**MIXED USE DEVELOPMENT (SSD-10378-MOD-2)- 42 HONEYSUCKLE DRIVE
NEWCASTLE**

I refer to the Department's electronic notification of 28 January 2022 advising a Section 4.5(1A) application has been received to modify the development consent (SSD-10378) for the above development and inviting City of Newcastle (CN) to provide advice. The application is seeking approval to amend the approved building design.

The Modification Report, Design Statement and modified architectural plans have been reviewed and the following advice is provided for the Department's consideration:

1 North Elevation

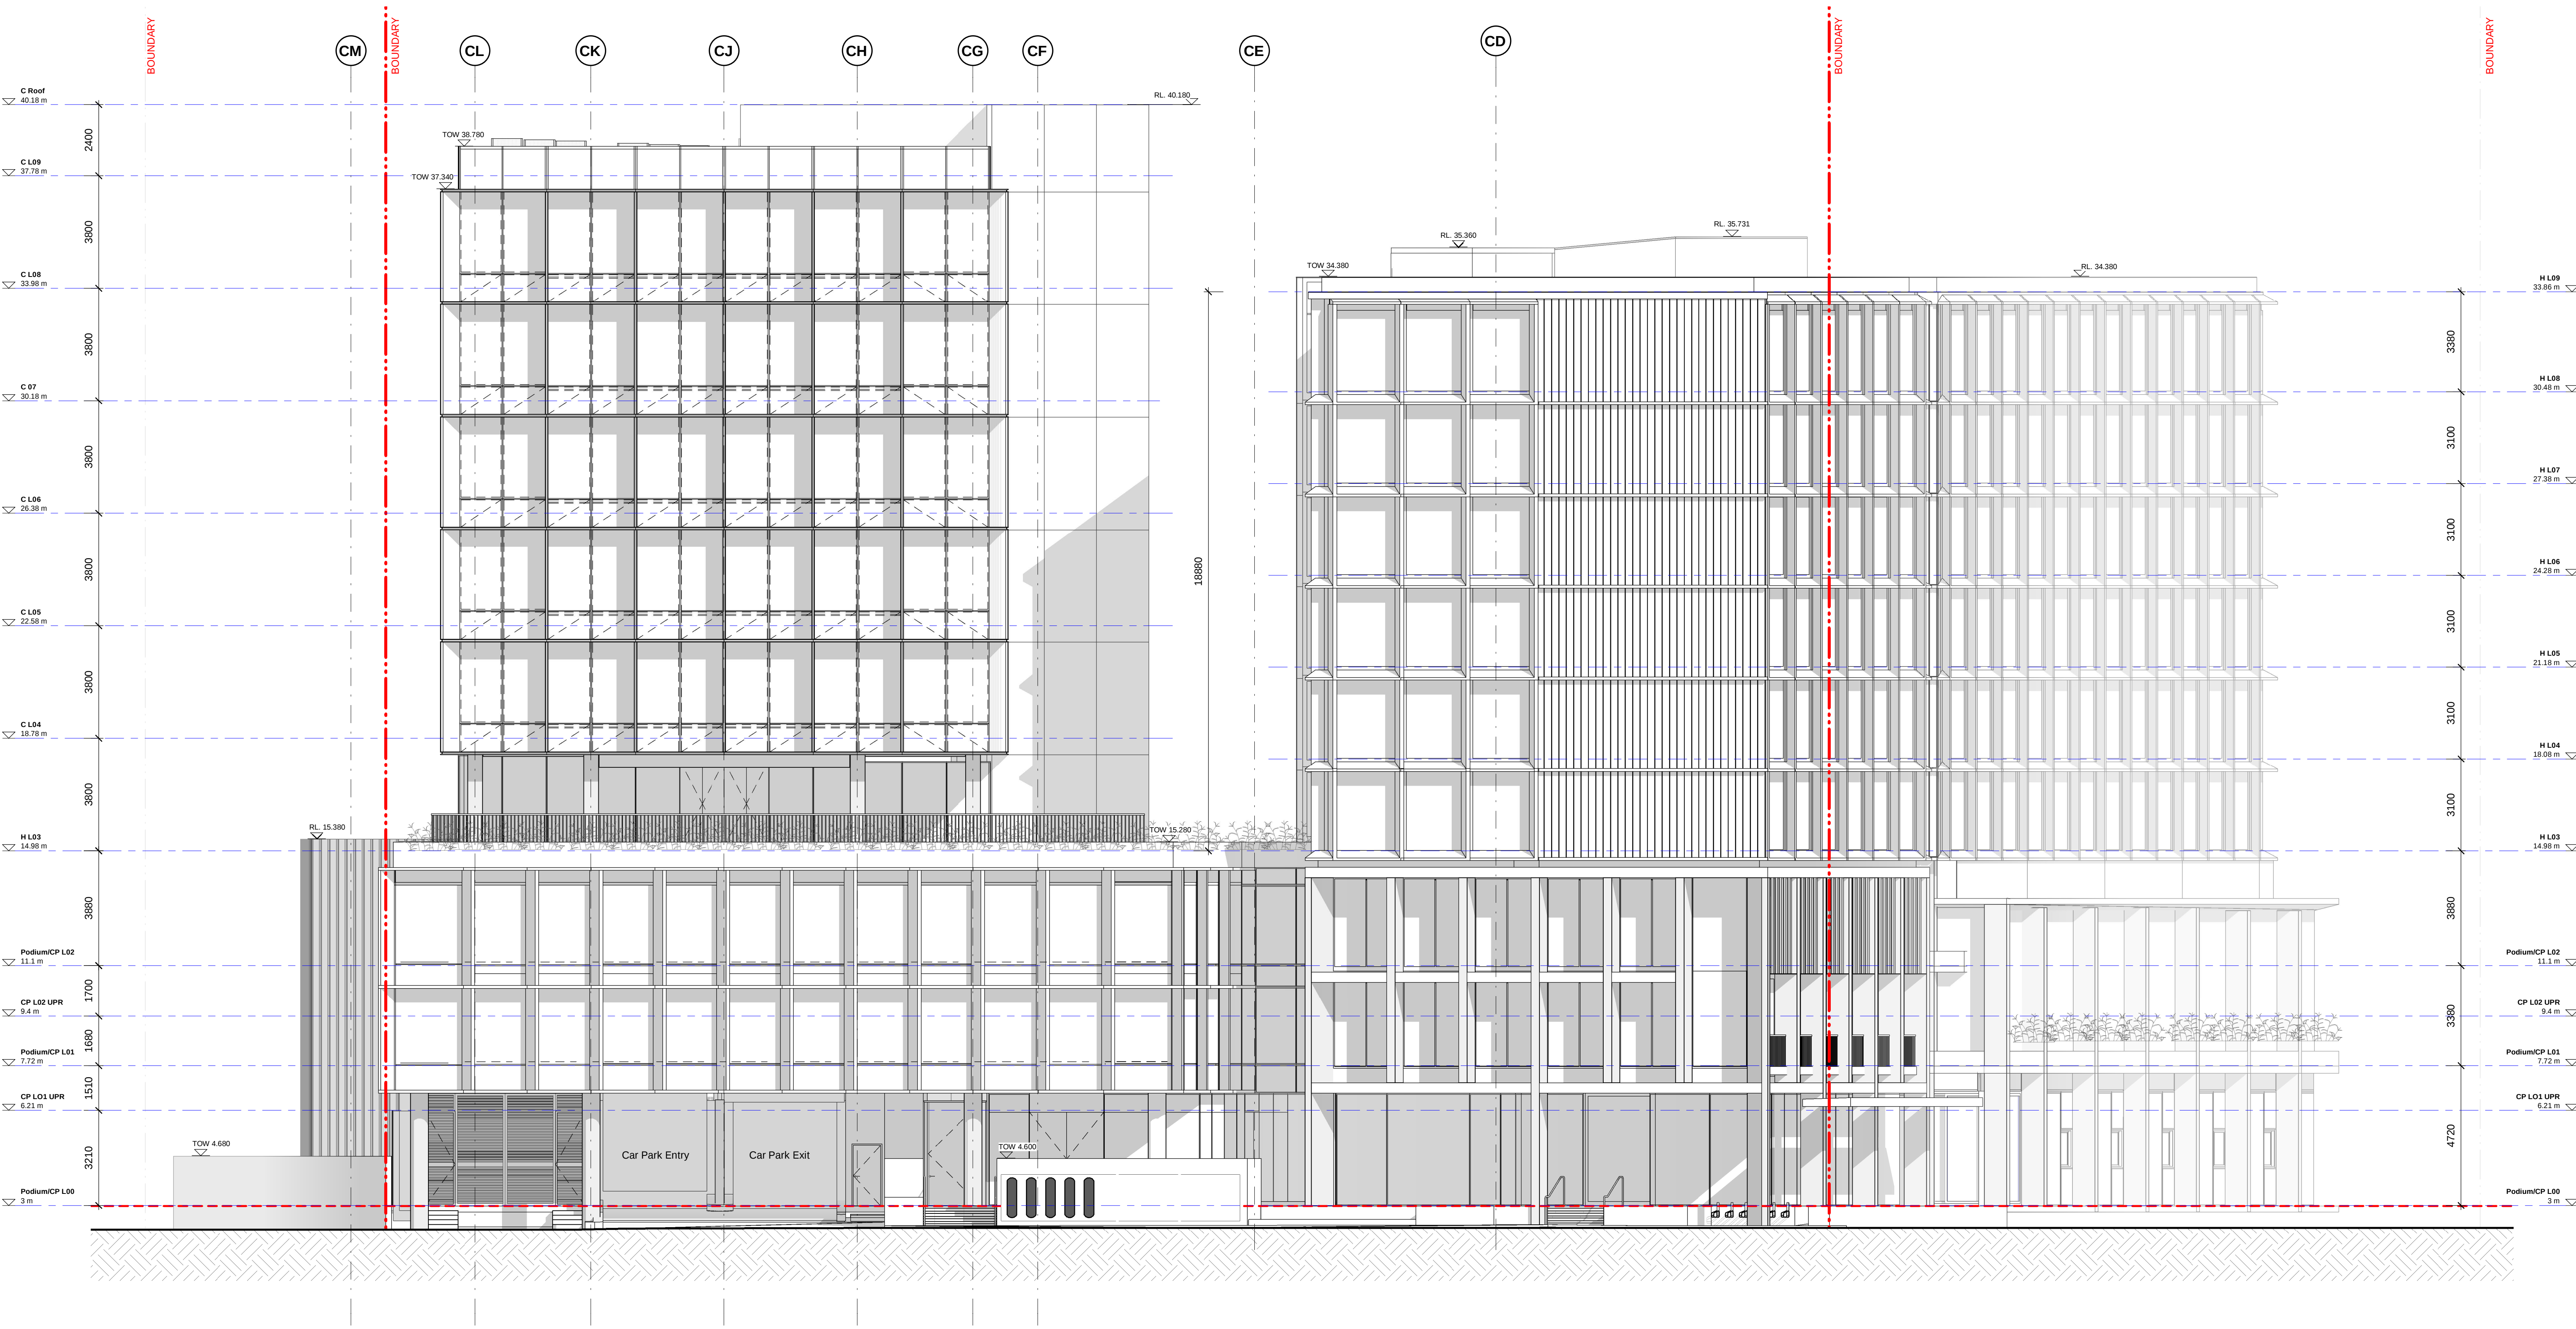
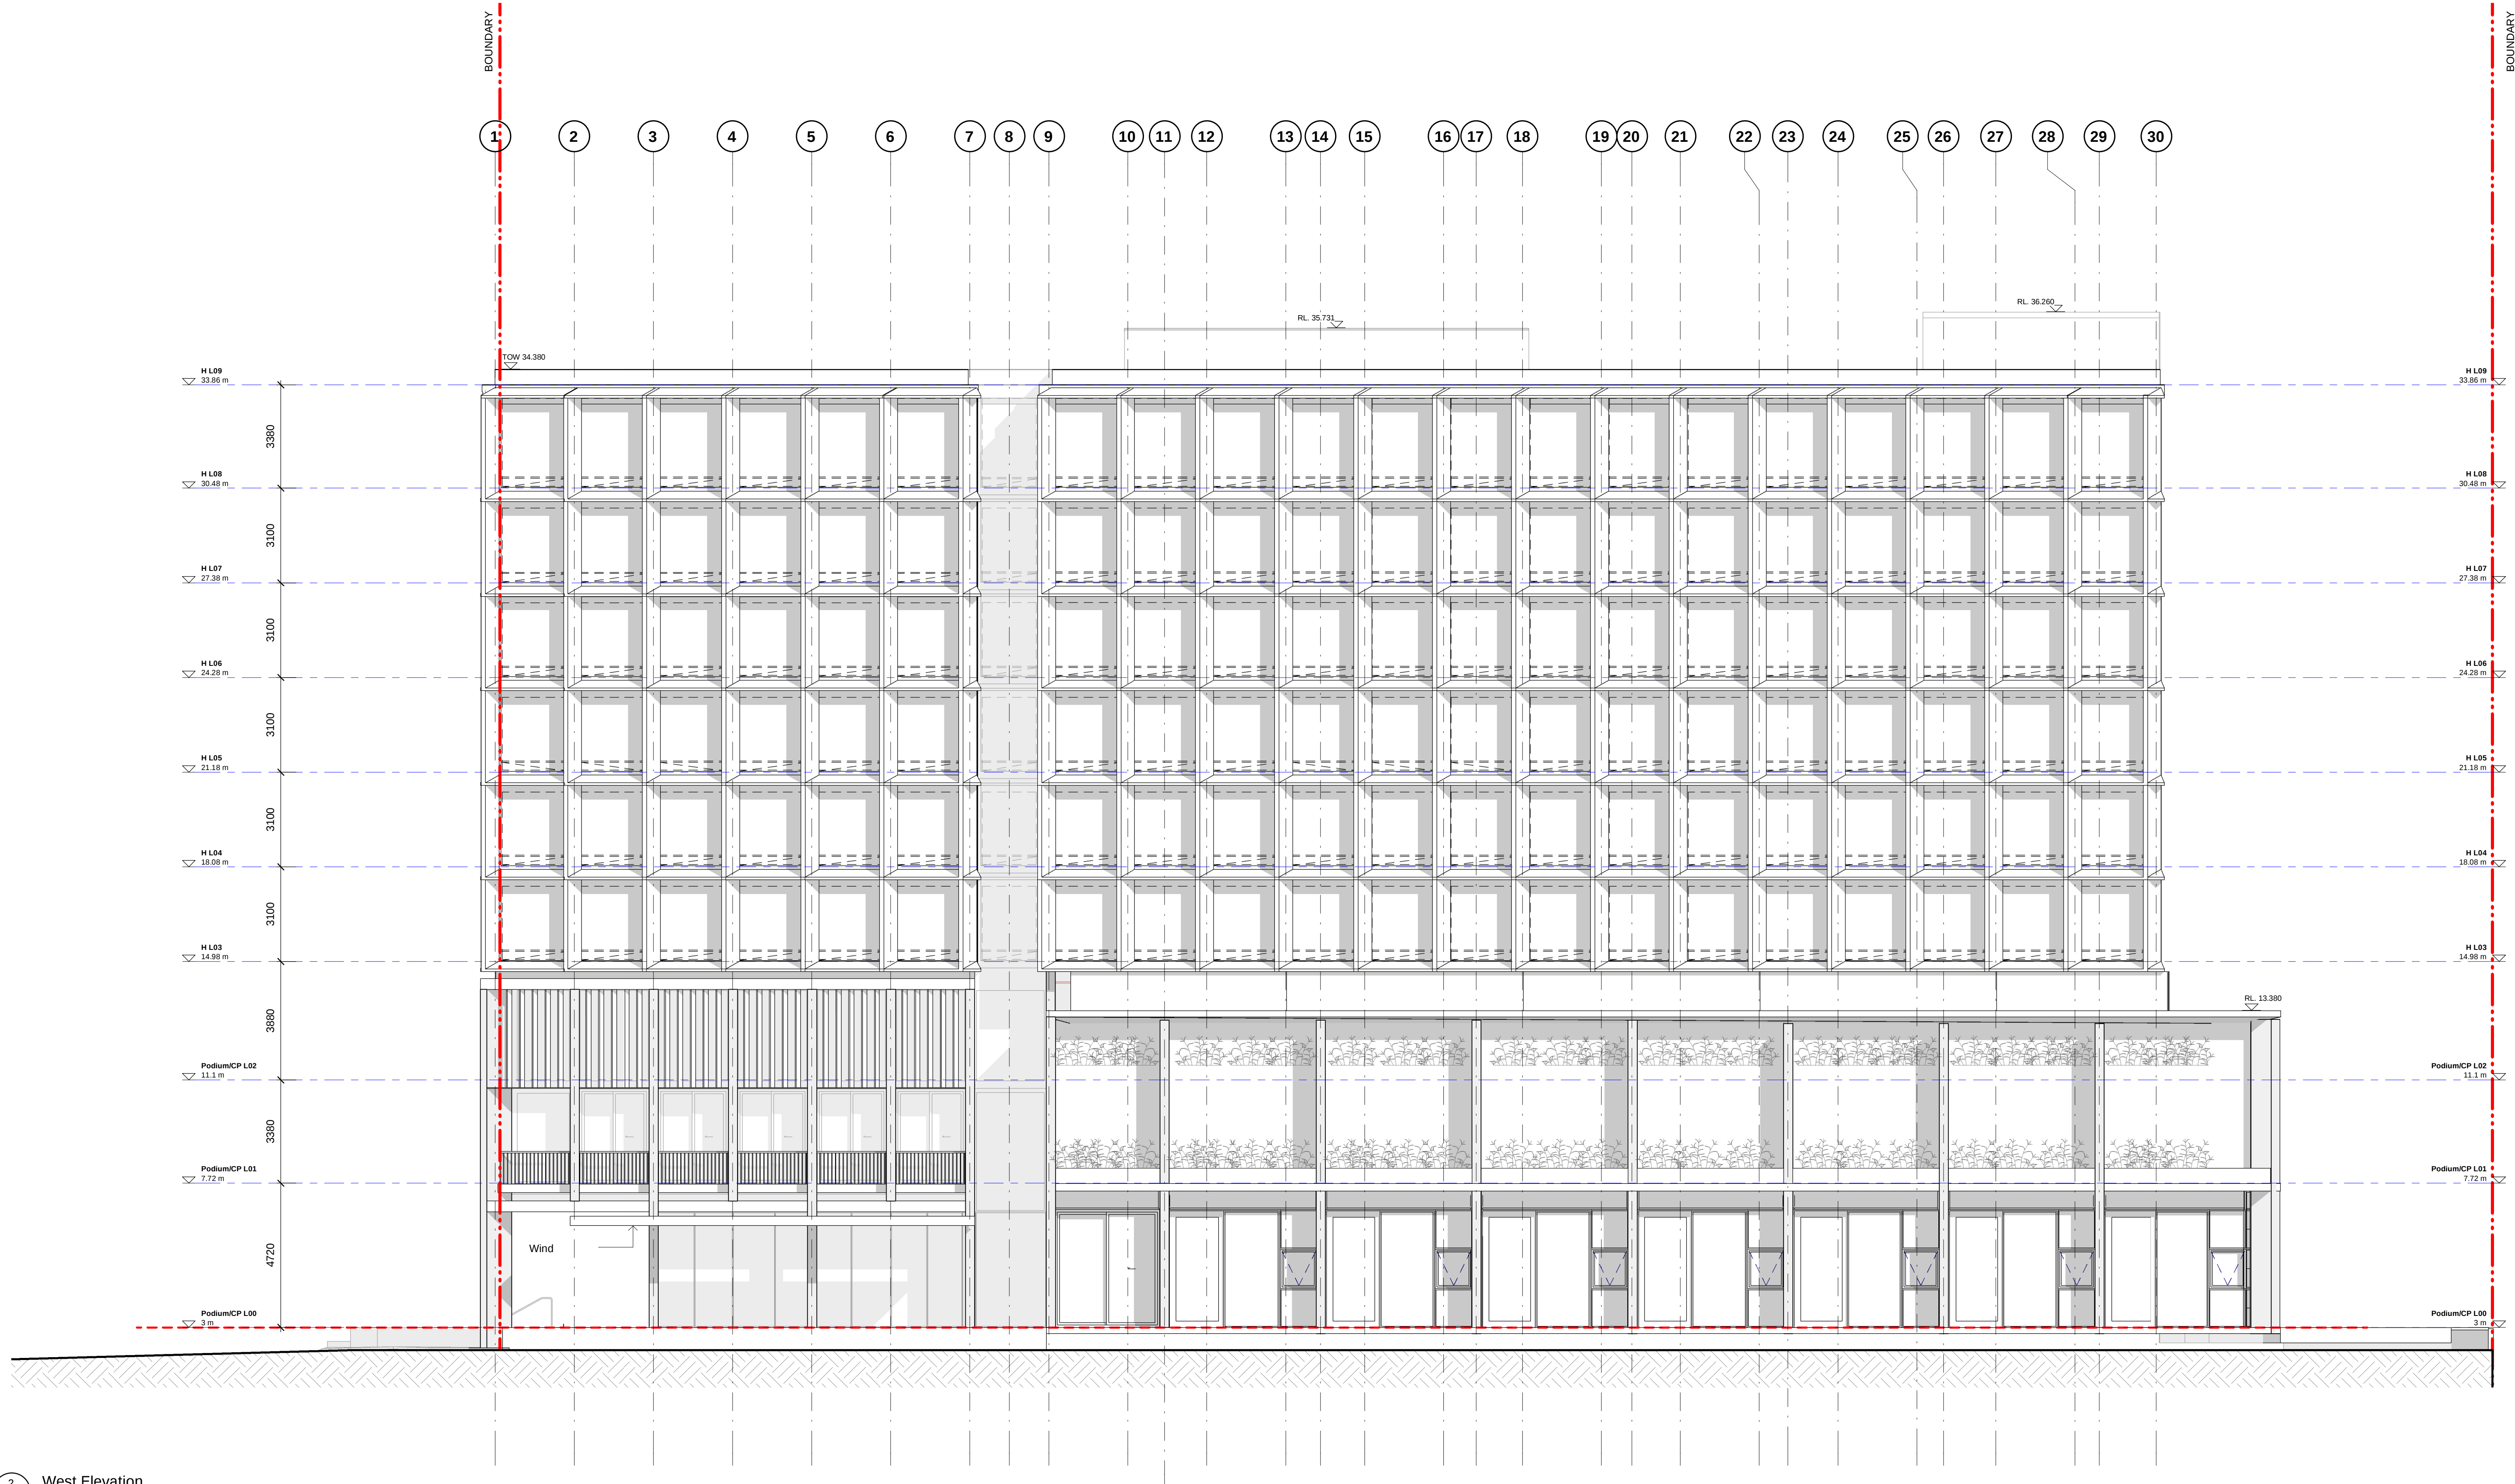
Concern is raised at the level of detail provided on the modified elevational plans compared to the approved plans. It is recommended the applicant is required to provide modified elevational drawings which show the same view and level of detail of the proposed modified development as provided for the approved development, including external colours, index of external building materials, and the approved building heights and proposed variations.

Furthermore, there appears to be changes proposed to the external appearance of the hotel and commercial building which are not acknowledged on the modified elevational plans.
